BRADLEY POINT FILING NO. 1 COUNTY OF EL PASO, STATE OF COLORADO GRADING/EROSION CONTROL PLANS

EL PASO COUNTY FILE NO. MS-21-002

BRADLEY POINT FILING NO. 1 GRADING & EROSION CONTROL PLAN PROJECT NO: 70-074 DATE: 08/16/23 SCALE: HORIZONTAL: N/A VERTICAL: N/A DESIGNED BY: VAS DRAWN BY: CWV CHECKED BY: DLN SHEET 1 OF 7 GR01

GRADING AND EROSION CONTROL PLAN

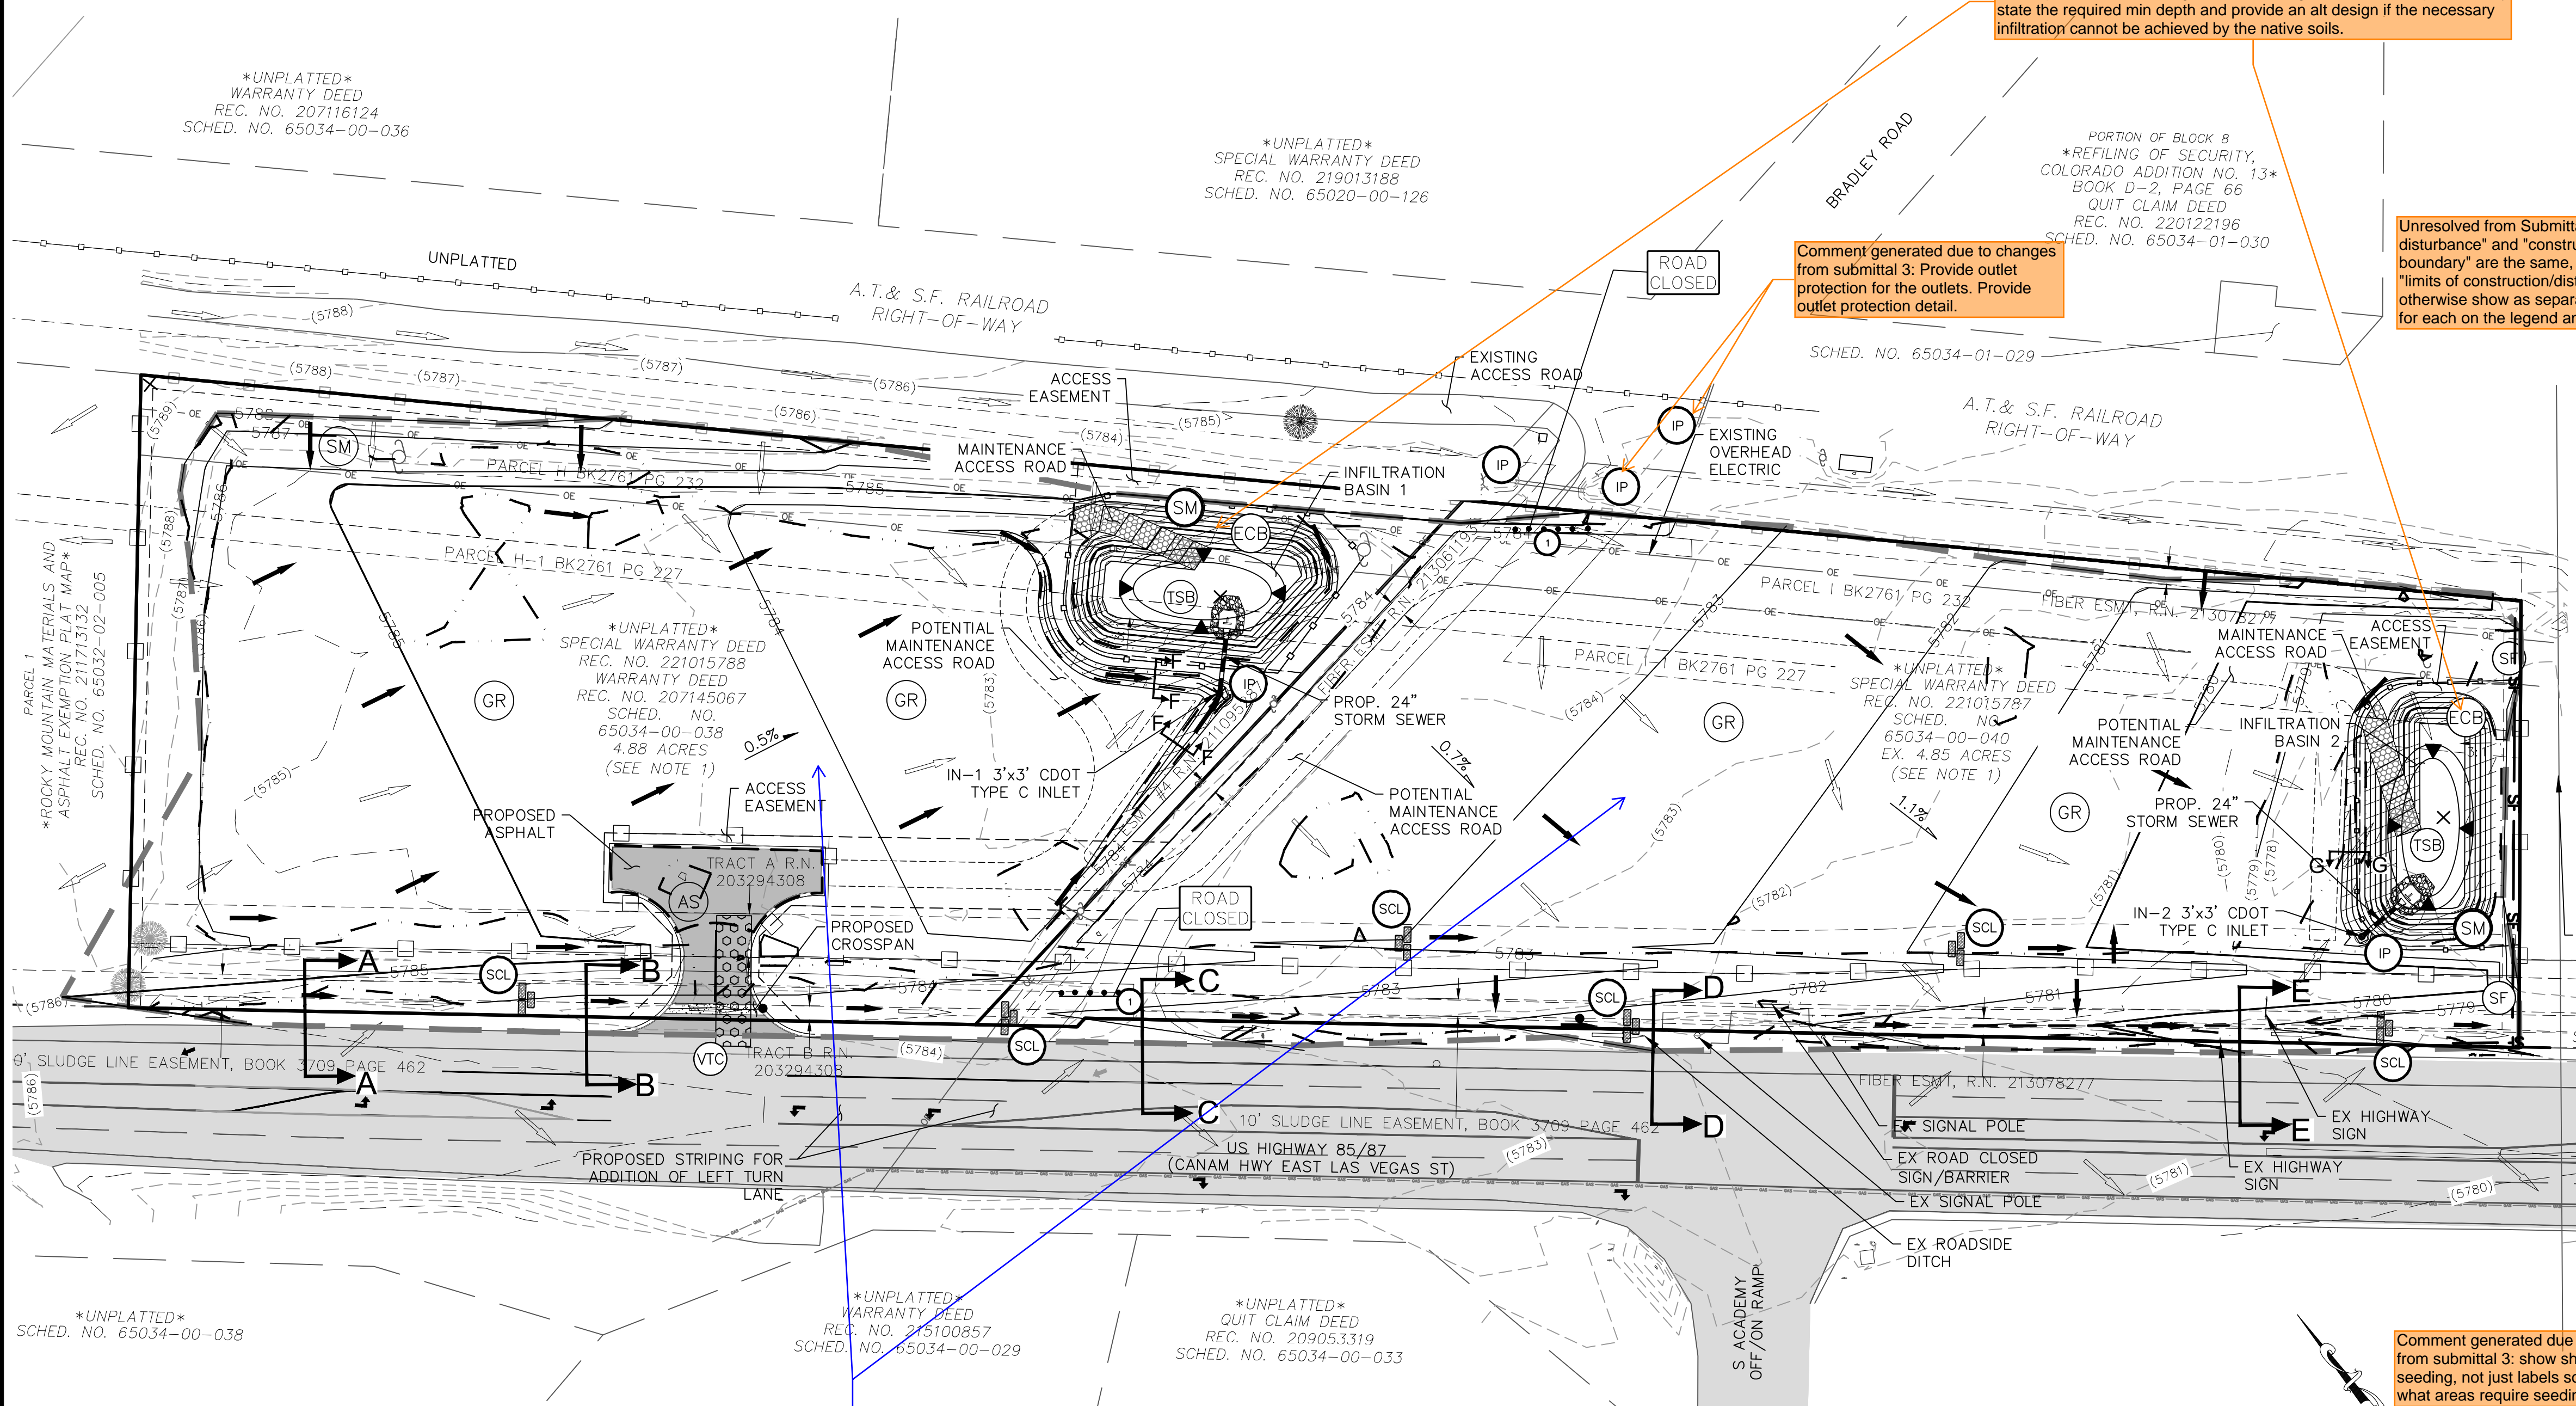
Unresolved from Submittal 4 - Add specifications for basins in the notes. The basin require excavation to a depth that has sands/gravels according to the Entech report. Clearly state the required min depth and provide an alt design if the necessary infiltration cannot be achieved by the native soils.

Per Jeff Rice discussion with Christina, a comment was added to discuss the native material used and the infiltration requirements.

Hi Darin,
 I've copied Christina - I think this was her comment. I think you can just add the requested statements as notes, such as "the infiltration basins must be constructed to meet the infiltration requirements of xx inches per hour per the Entech study dated xxxx. If the native materials do not meet this requirement, they shall be replaced with materials that do and are acceptable to the design engineer." (or something similar if you want to be more specific)
 Christina - please let Darin know if we need more than that.
